Please upload onto Ocella the email below, and the attachment, which is a further consultation response from the Local Highway Authority to discharge of condition application **Y/139/20/DOC** relating to Land South of Ford Lane and East of North End Road, Yapton.

**TEMPORARY CONSTRUCTION ACCESS
FORD LANE, YAPTON, WEST SUSSEX**

**DESIGNER'S RESPONSE TO ROAD
SAFETY AUDIT STAGE 1/2**

Scale 1:200 @A1	Date SEP 20	Designed JA
Drawn JA	Checked SG	Approved LH
Job No 18-344	Drawing No 18-344/702	Rev B

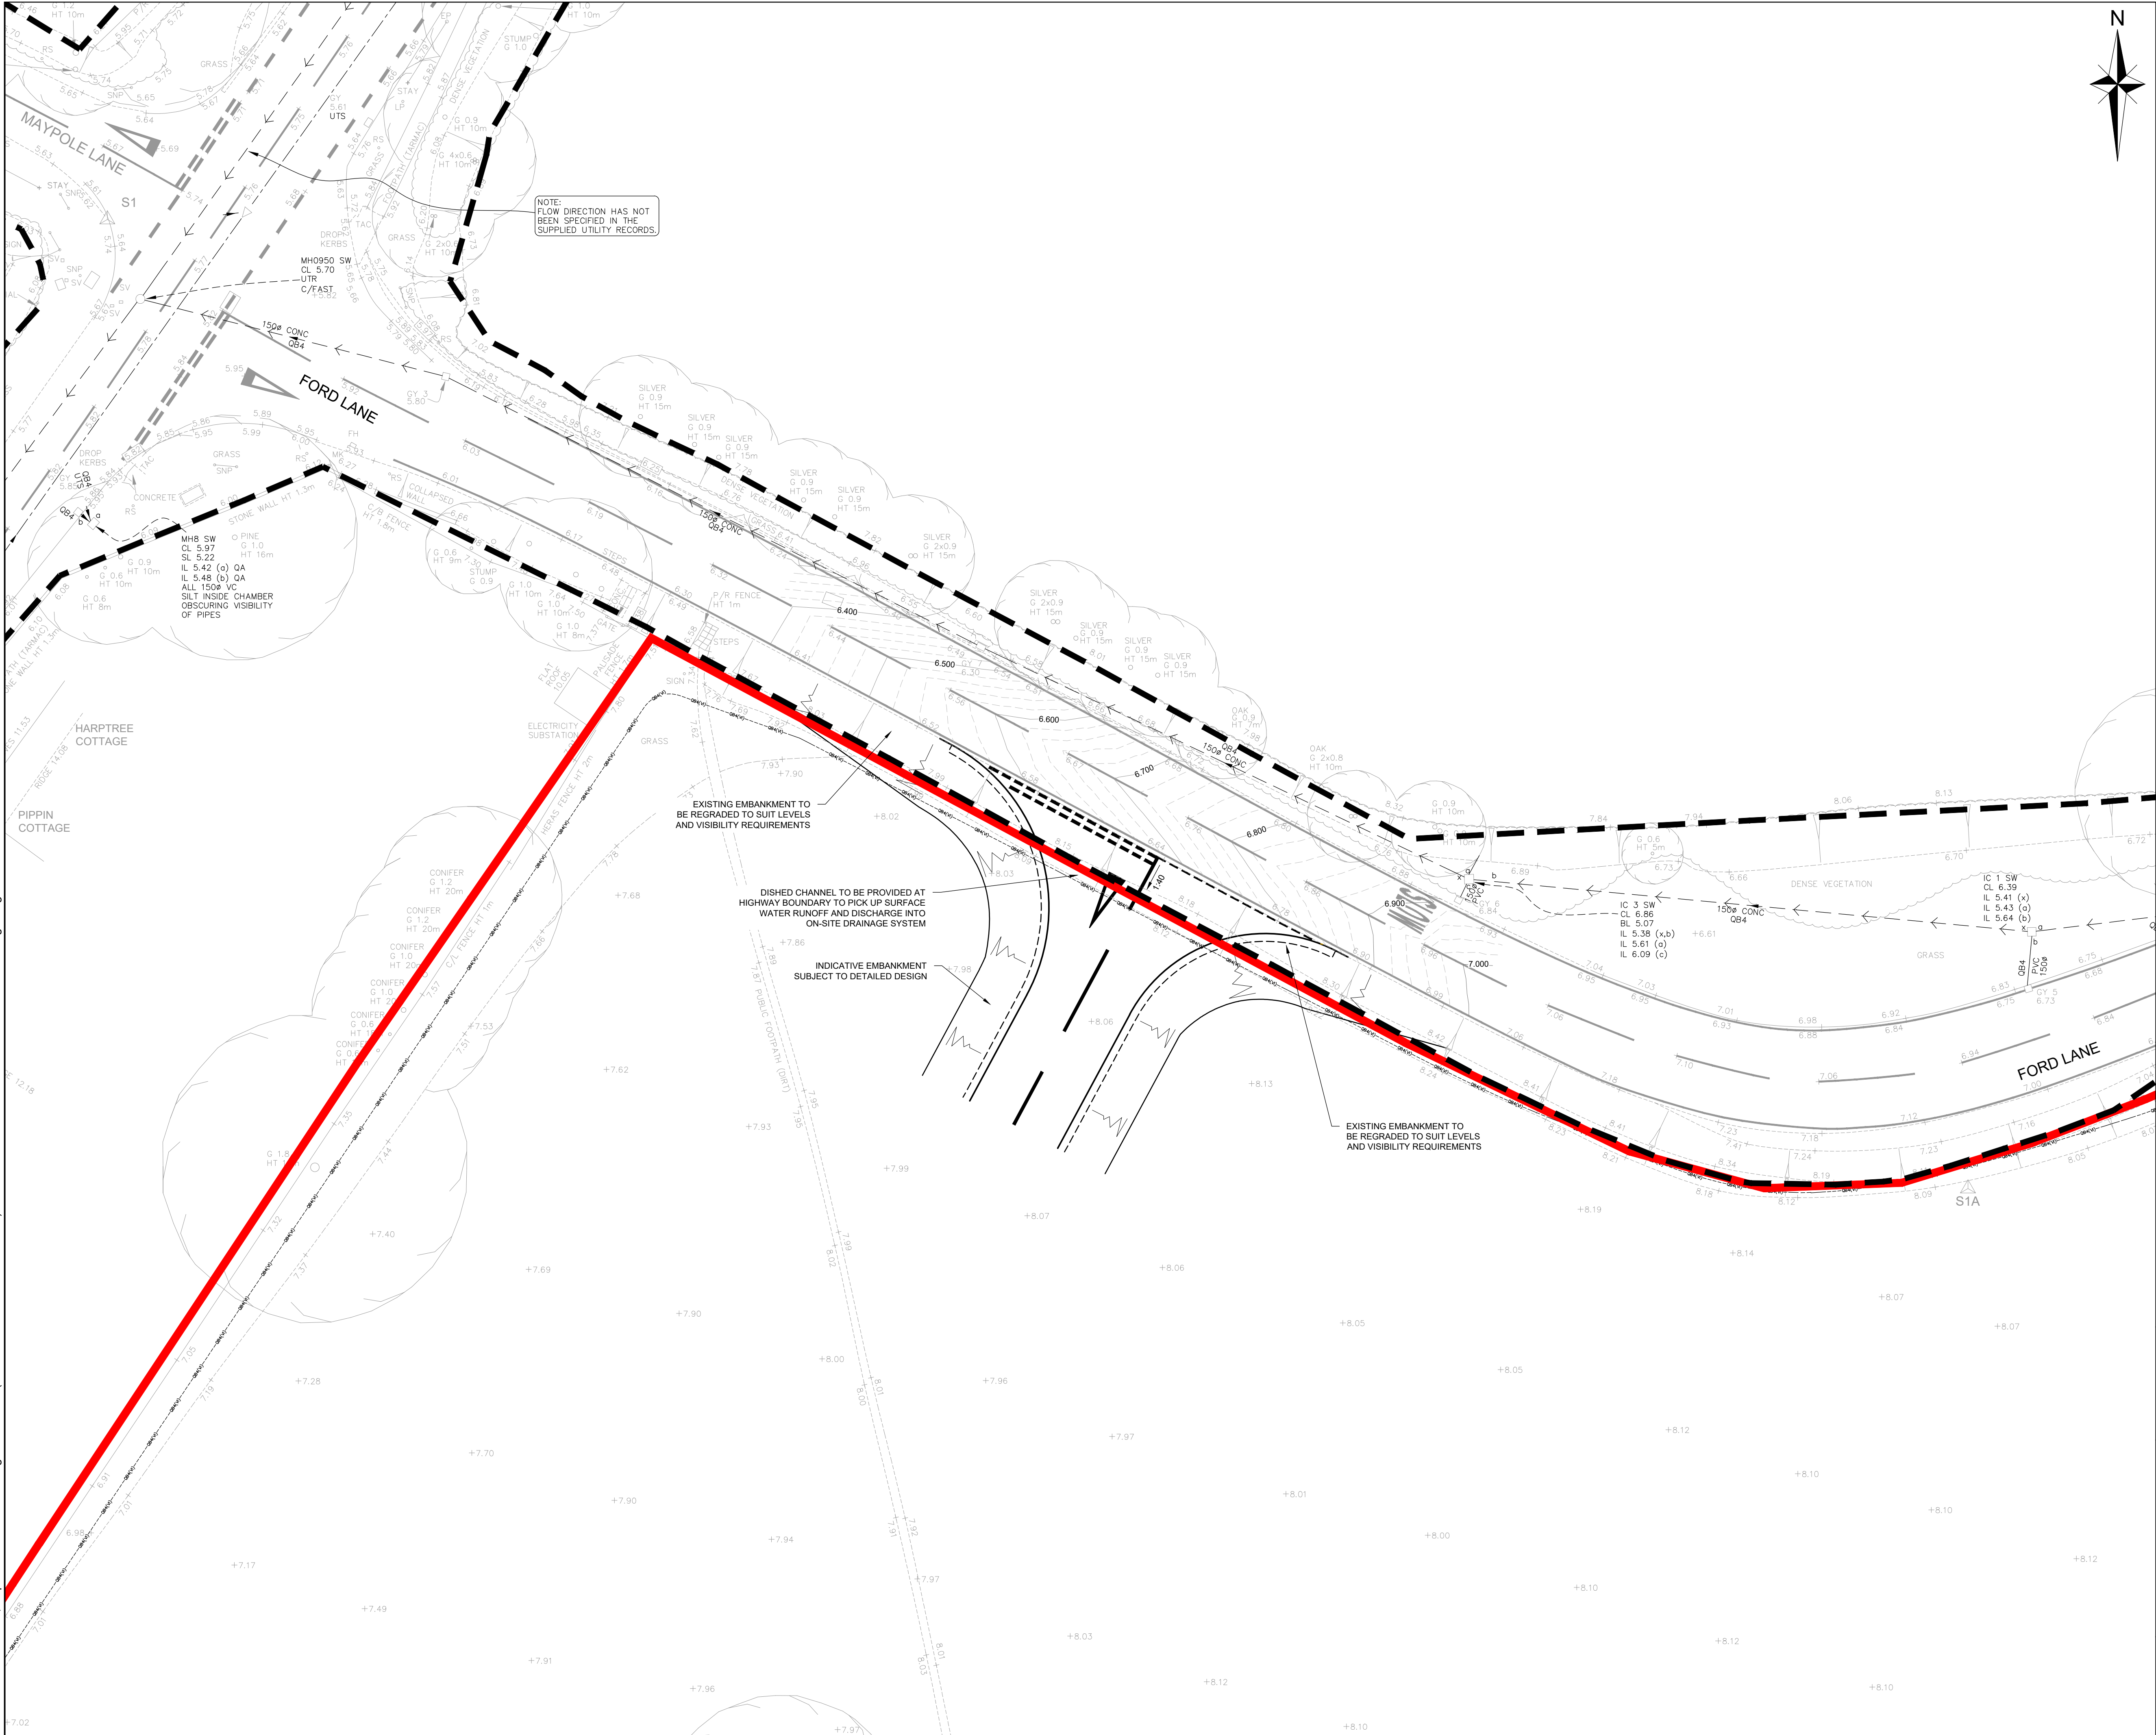
3.1	GENERAL				
3.1.1	PROBLEM Location: At the proposed access. Summary: Ponding of surface water could lead to loss of control collisions. Kerblines are being amended as part of these proposals, and the land slopes towards Ford Lane. No details have been provided regarding the proposed carriageway drainage, where inadequate drainage provision could cause possible ponding, which could lead to loss of control collisions.	It is recommended that drainage details and carriageway profiles should be such that surface water is shed to an appropriate surface water system.	Recommendation acknowledged. The proposed access levels have now been adjusted such that any localised surface water will drain towards the site access and into the on-site surface water system.	Agree with both the Auditor's recommendation and Design Organisation Response.	That the proposed access levels will be adjusted such that any localised surface water will drain towards the site access and into the on-site surface water system.

Scale	Date	Designed
1:200 @A1	AUG 20	SG
Drawn	Checked	Approved
JA	SG	LH
Job No	Drawing No	Rev
18-344	18-344/701	F

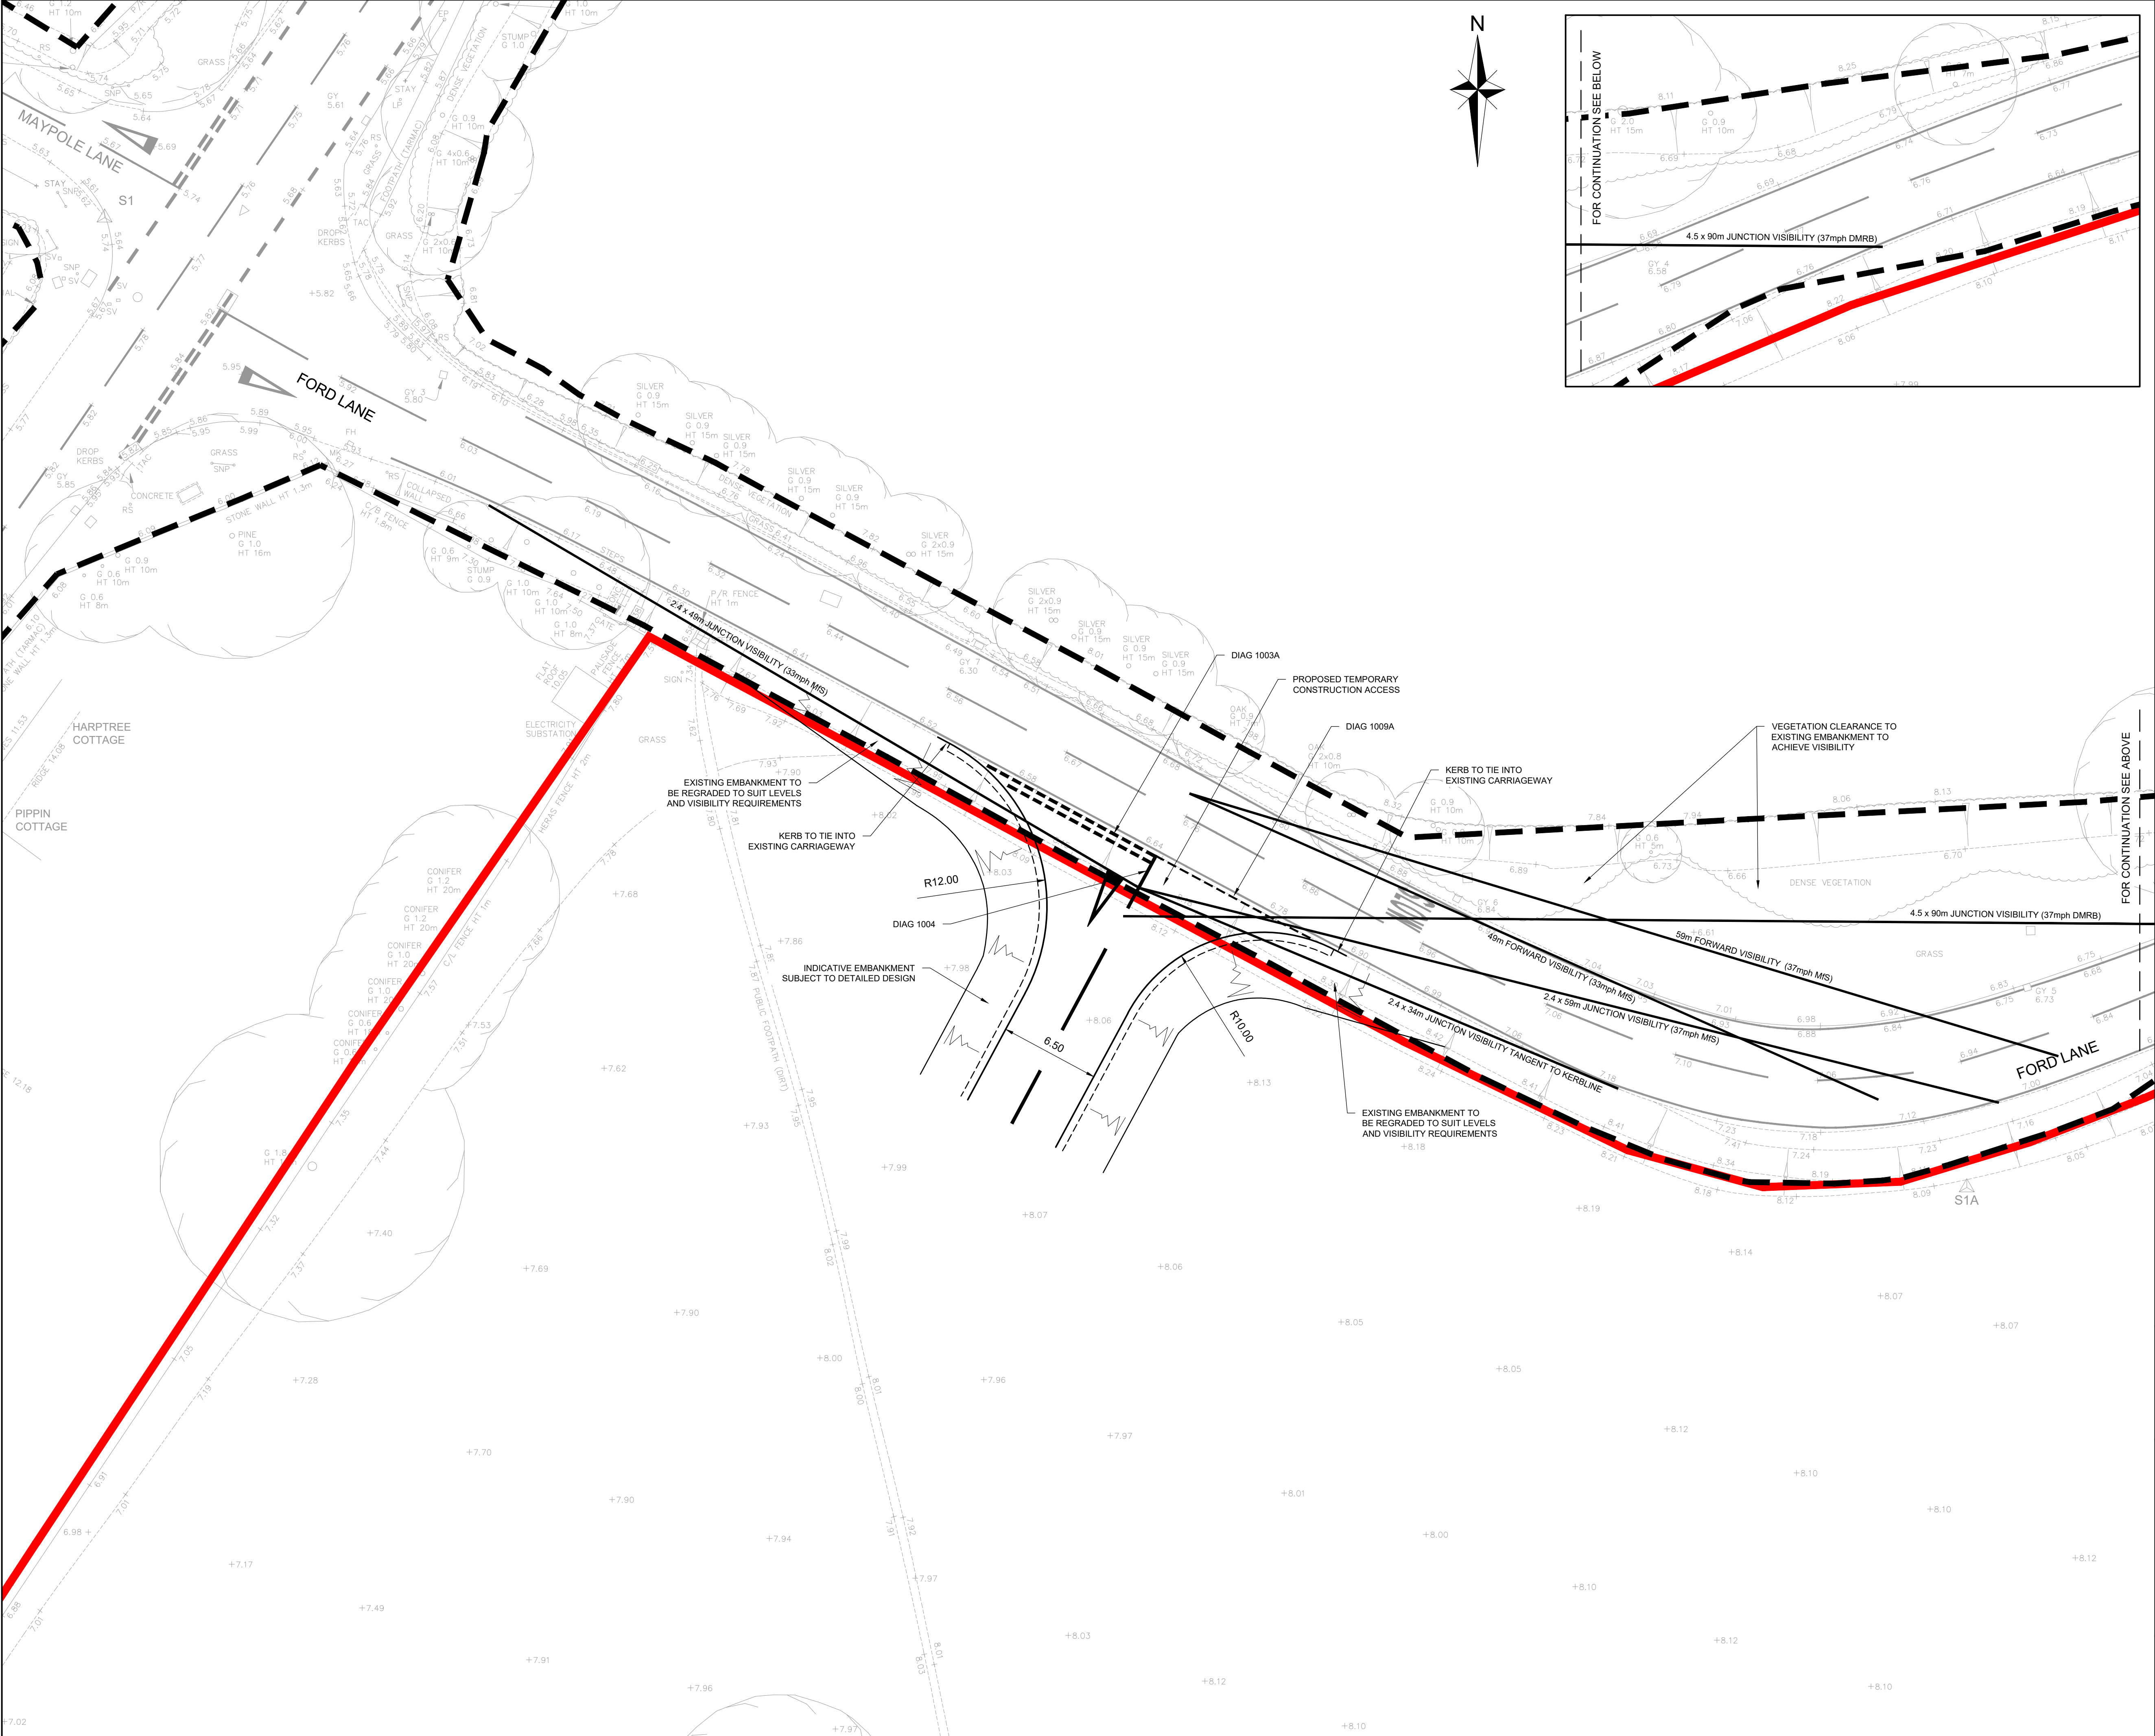
3.3	JUNCTIONS				
3.3.1	PROBLEM				
	Location: At the proposed access. Summary: Insufficient visibility could lead rear end shunt head on or side impact collisions. Ford Lane is subject to National speed limit, visibility splays have been provided for 34m and 43m for the proposed access, which may be insufficient for the vehicle approach speeds. Further, no forward visibility splays have been provided for vehicles waiting to turn right	It is recommended that forward and junction visibility splays should be commensurate with traffic speeds. Further that forward visibility splays and traffic speeds should be provided for assessment.	Further traffic speed data has now been made available and visibility splays have been updated to reflect this. 85th percentile speeds were recorded at 37mph for westbound traffic and 33mph for eastbound traffic.	Agree with both the Auditor's recommendation and Design Organisation's response.	That the access be provided with junction and forward visibility splays commensurate with traffic speeds as set-out in speed survey undertaken 4th November 2020 provided by Paul Castle and shown on Odyssey Transport Consultants' drawing No. 18-344/701 F.

Audit Item No.	RSA Problem	RSA Recommendation	Design Organisation Response	Overseeing Organisation Response	Agreed RSA Action
	into the proposed access where visibility is restricted see figures 1 and 2 below.  Insufficient visibility splays and forward visibility splays could lead to rear end shunt head on or side impact collisions.  Figures 1 and 2: Restricted visibility.
